**Application by:- Norfolk Vanguard Limited for an Order Granting Development Consent for the Norfolk Vanguard Offshore Wind Farm Project
The ExA's Written Questions and Requests for Information**

Your Ref: EN010079
Date: 15 January 2019

Please find below answers to the highway elements of your request from Norfolk County Council (NCC) in its capacity as Local Highway Authority (LHA).

Title:
ExA; ISH; 10.D3.1A
Location of Hornsea Project Three main compound

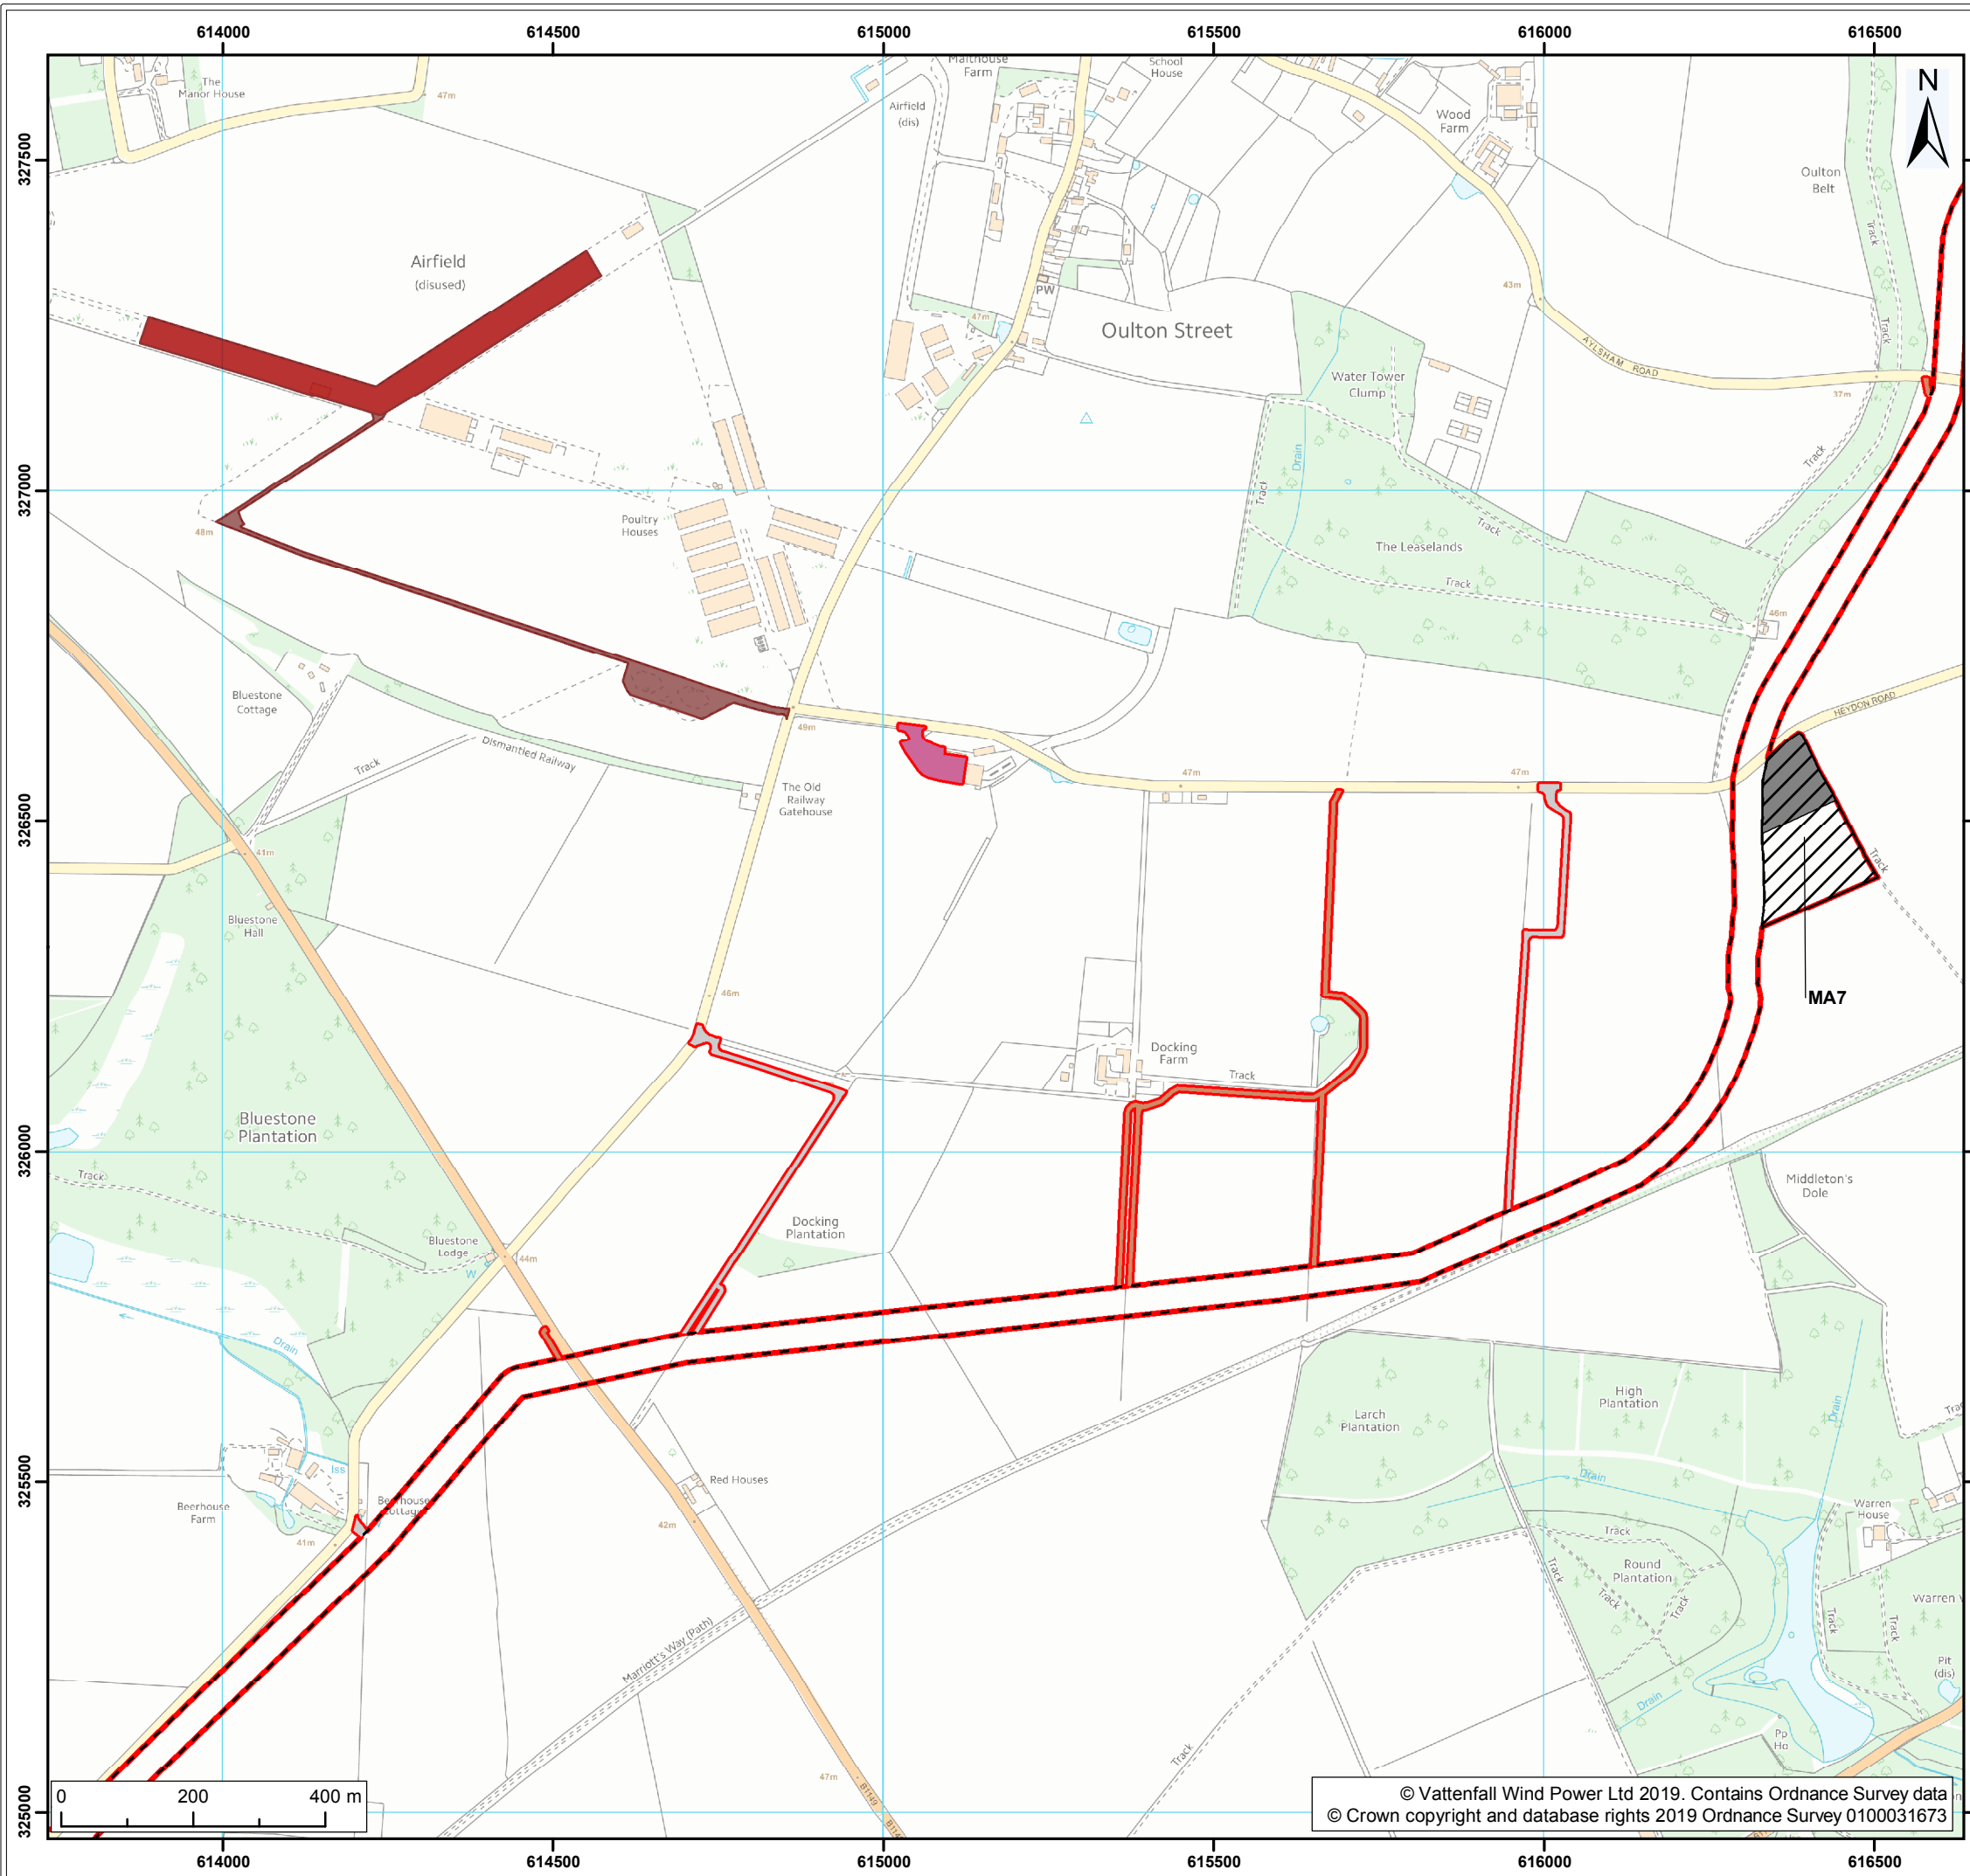
It has subsequently been clarified that whilst Orstead propose to use link 68 to gain access to their main compound, Vanguard intend to use this link in a less intensive manner as access to a mobilisation area. Nevertheless, our assessment has still been made against the Applicants stated traffic figures and our concerns remain as set out within our response to Qu 11.1 above.

PROJECT HORNSEA 3 OFF-SHORE WIND FARM	DATE 18.09.18	DRAWING STATUS INFORMATION	
DRAWING TITLE PROPOSED IMPROVEMENTS THE STREET, OULTON (OPTION 1) SHEET 2 OF 2	SCALE(S) 1:1,000	DESIGNED MDA	
CLIENT ORSTED	JOB No 1554	CHECKED PZ	APPROVED PZ
	DRAWING No 03/102	REVISION A

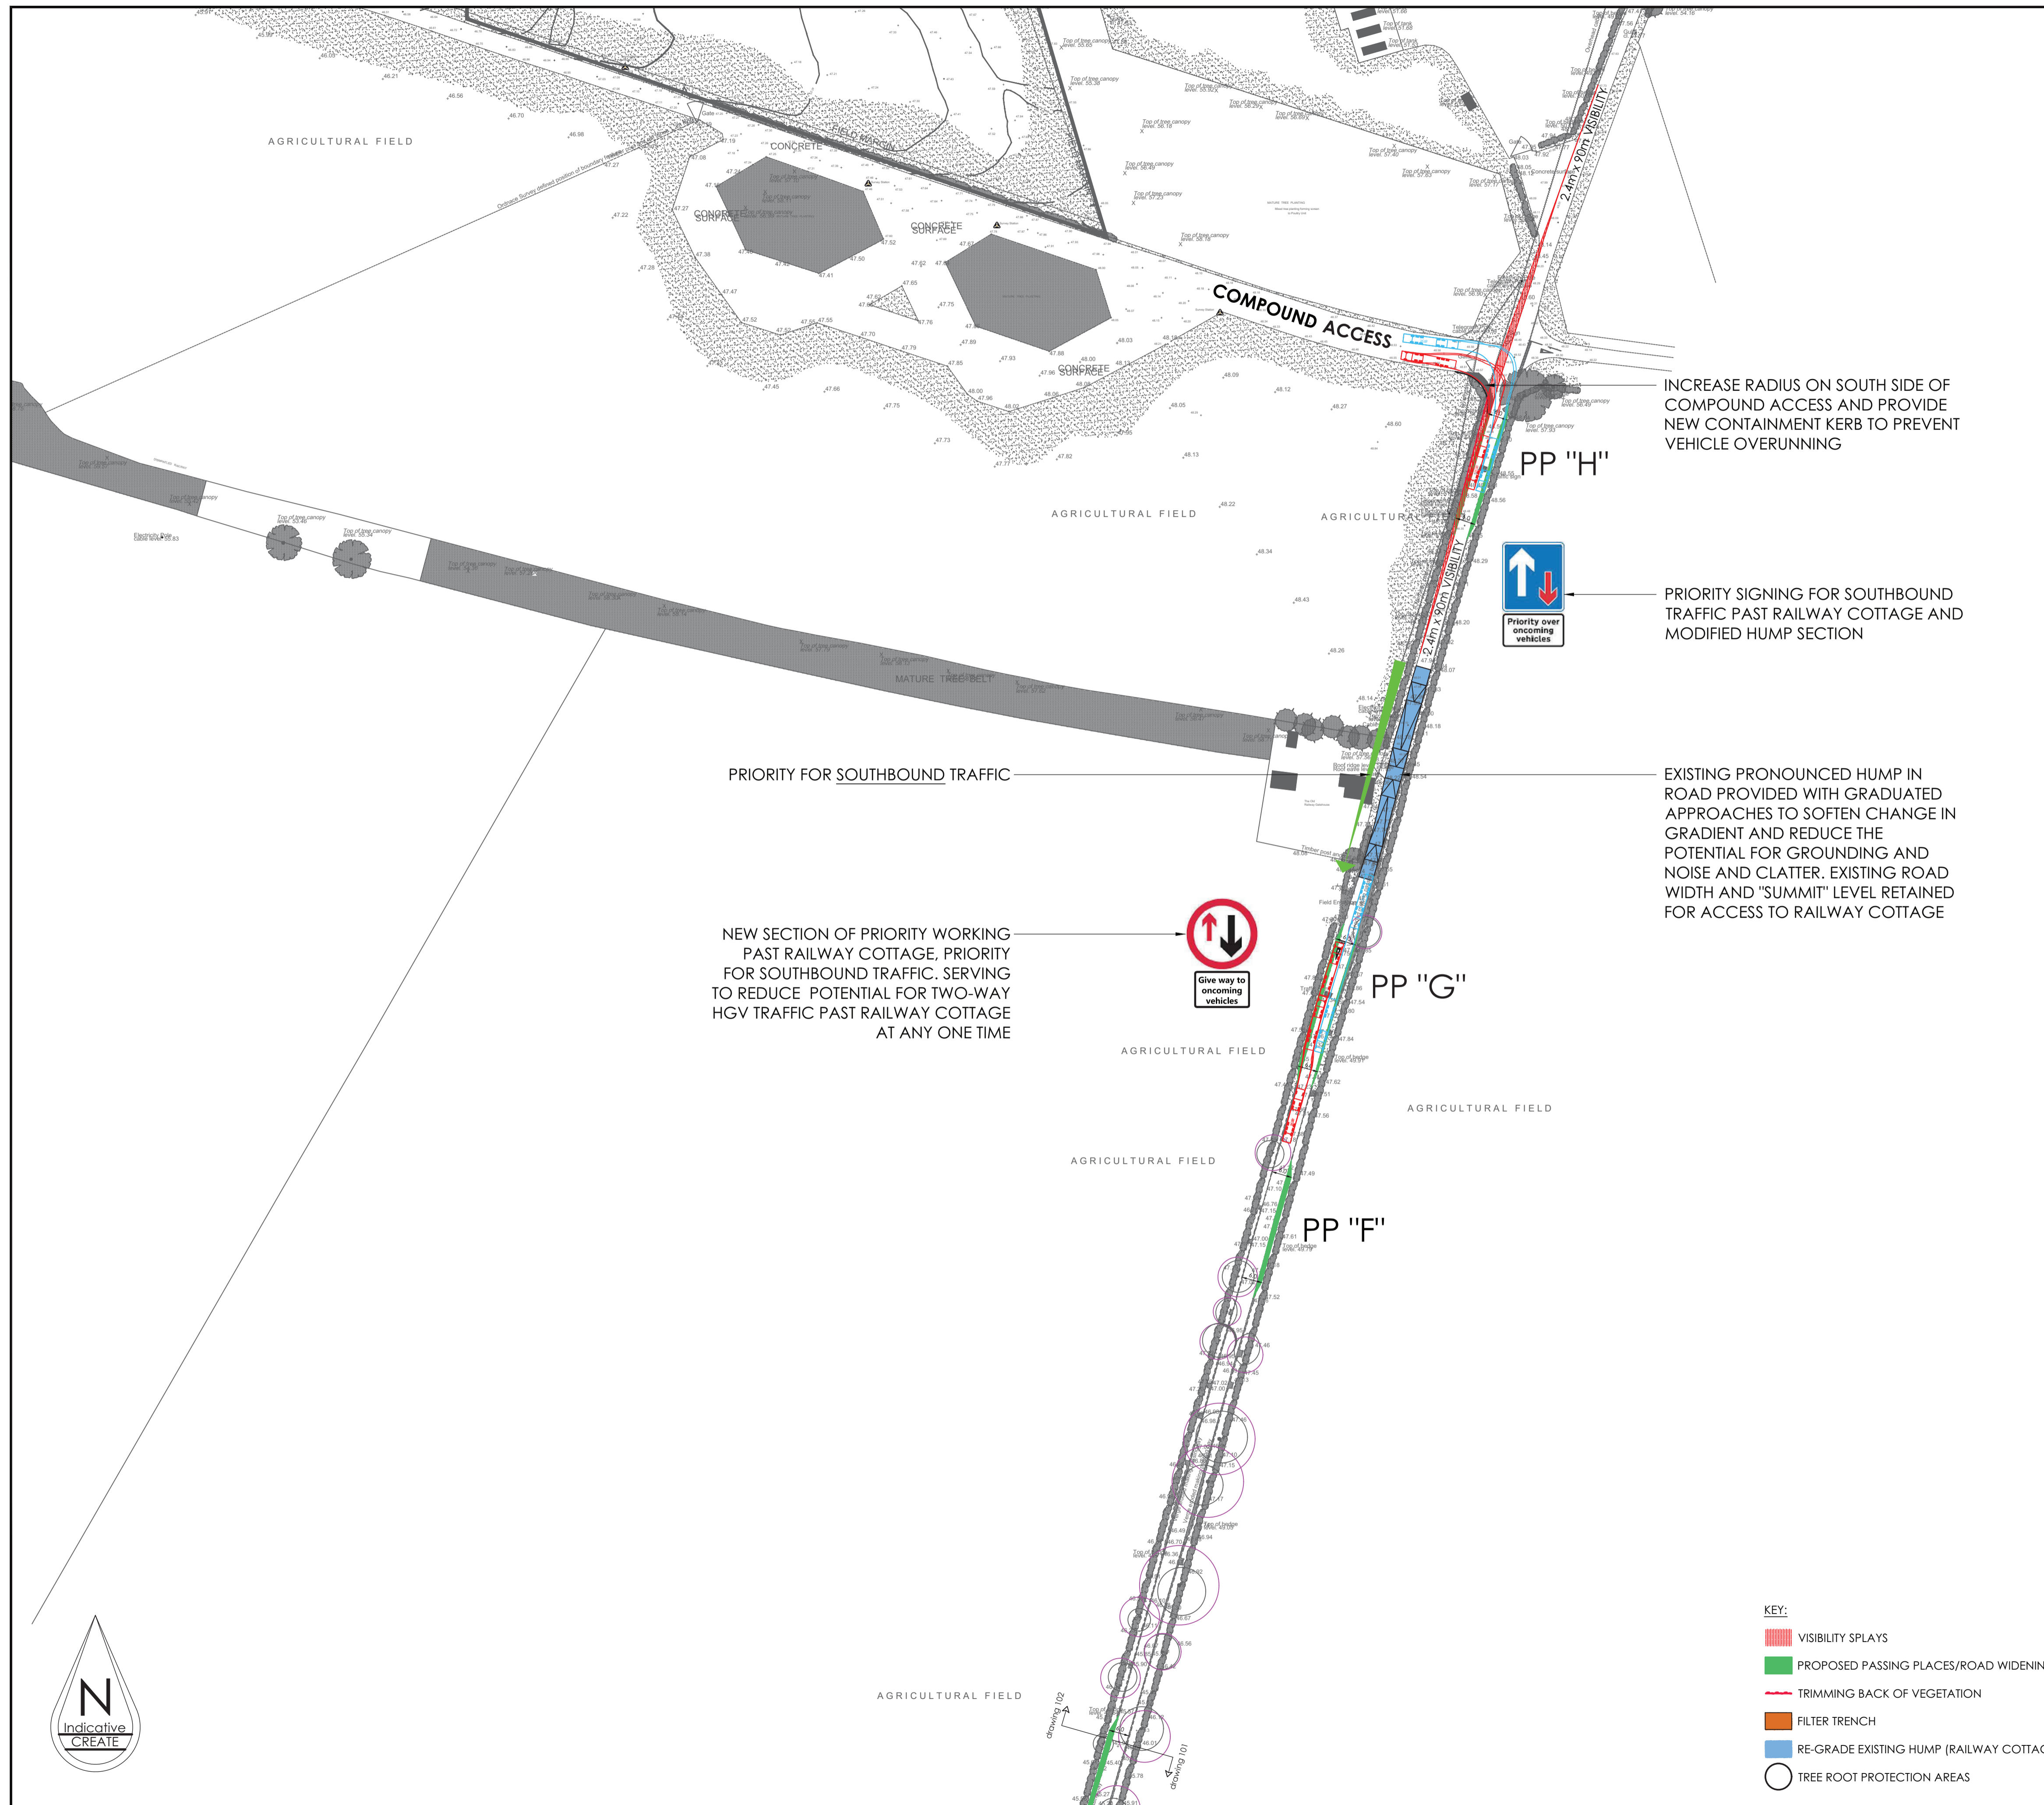
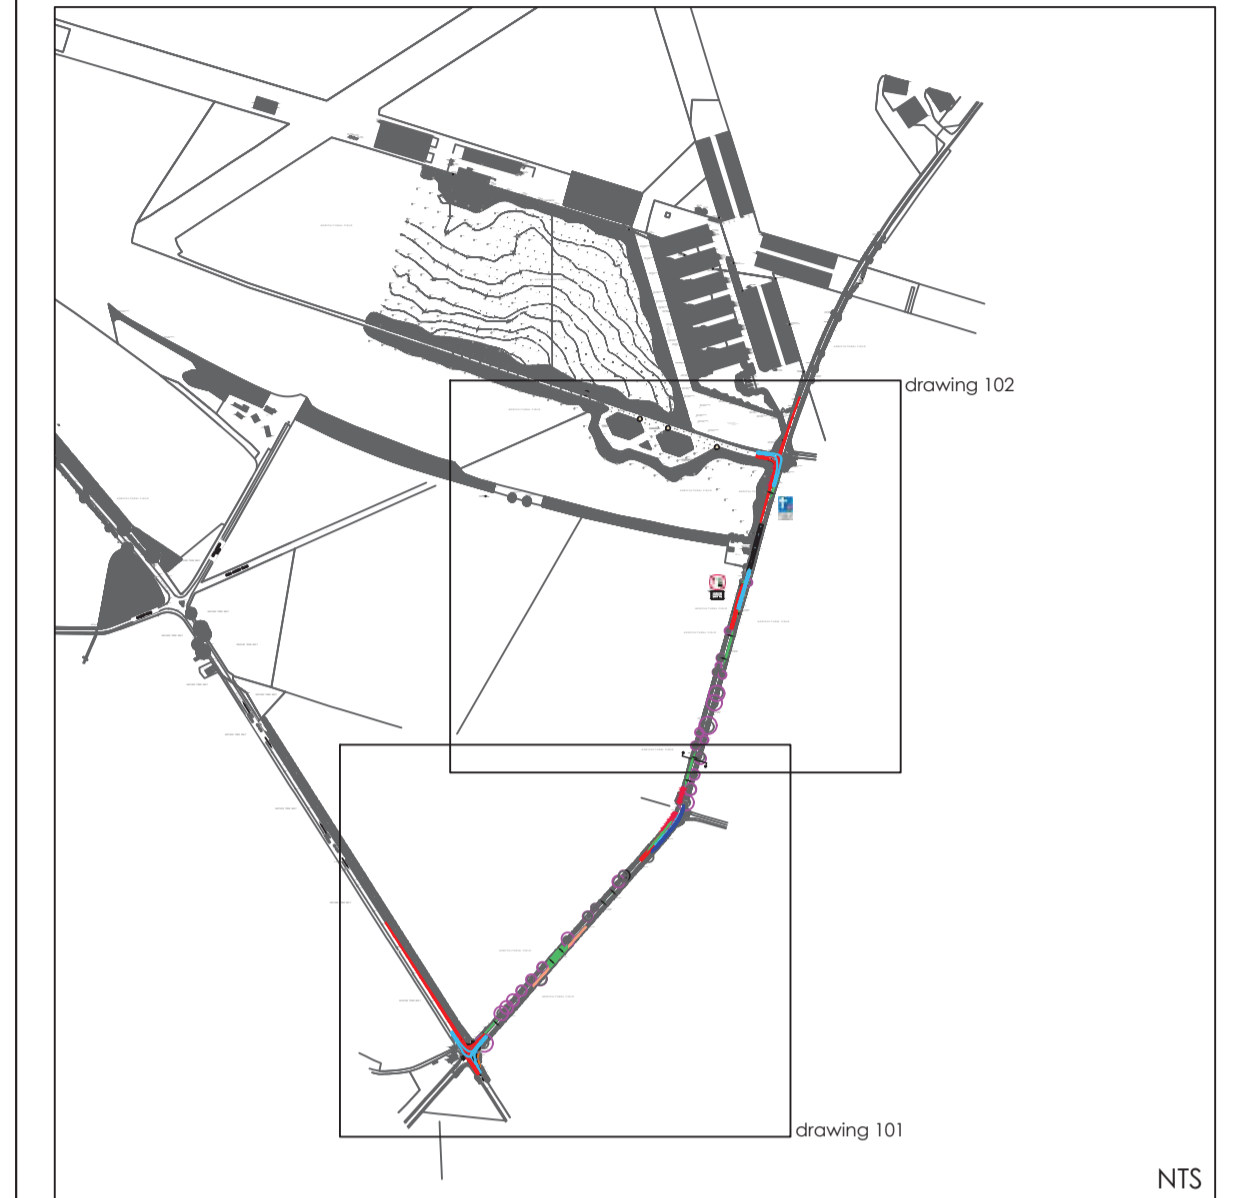
Link 68 (The Street at Oulton) which serves mobilisation area MA7 is identified as requiring traffic management measures. The Applicants intended solution is to use a pilot vehicle to guide traffic into passing places. However, no suitable passing places exist. Minor improvements are also required to aid forward visibility. Providing a pilot vehicle without addressing the narrowness of the road simply exacerbates the problem - the Applicants are just adding to the number of vehicles on the road which are then in turn also competing to pass.

The LHA draw your attention to the fact that traffic associated with the Hornsea 3 wind farm proposal also intends to utilise link 68 (albeit in a more intensive manner). The LHA supports a mitigation scheme proposed by Orstead (the Applicants for Hornsea 3) which we believe overcomes the issue of either Vanguard or Orstead using link 68 **independently of each other**. We are simply looking for Vanguard to provide the same package of temporary off-site highway works but they are reluctant to do so.

The Applicants intention is that a "...pilot vehicle would exit the access and travel to a designated layby/passing place. The pilot vehicle would then temporarily stop oncoming traffic and radio to the HGV driver to exit the site and traverse to the designated passing place. **However, there are no suitable passing places. Accordingly, the Applicants solution simply cannot work.**

Our profession advice is that whichever project comes along first needs to deliver a scheme of mitigation works to provide passing provision. However there also needs to be (i) an assessment of cumulative impacts and (ii) an agreement between Vanguard and Orsetead as to who will subsequently remove the mitigation works and re-instates the highway.

We believe there is a realistic and proportionate solution. We are simply looking for Vanguard to provide the same package of mitigation works as Orstead but they are reluctant to do so. **In the circumstances we have no option but to maintain our holding objection with a view to upgrading that to a full recommendation of refusal if the issue is not addressed.**
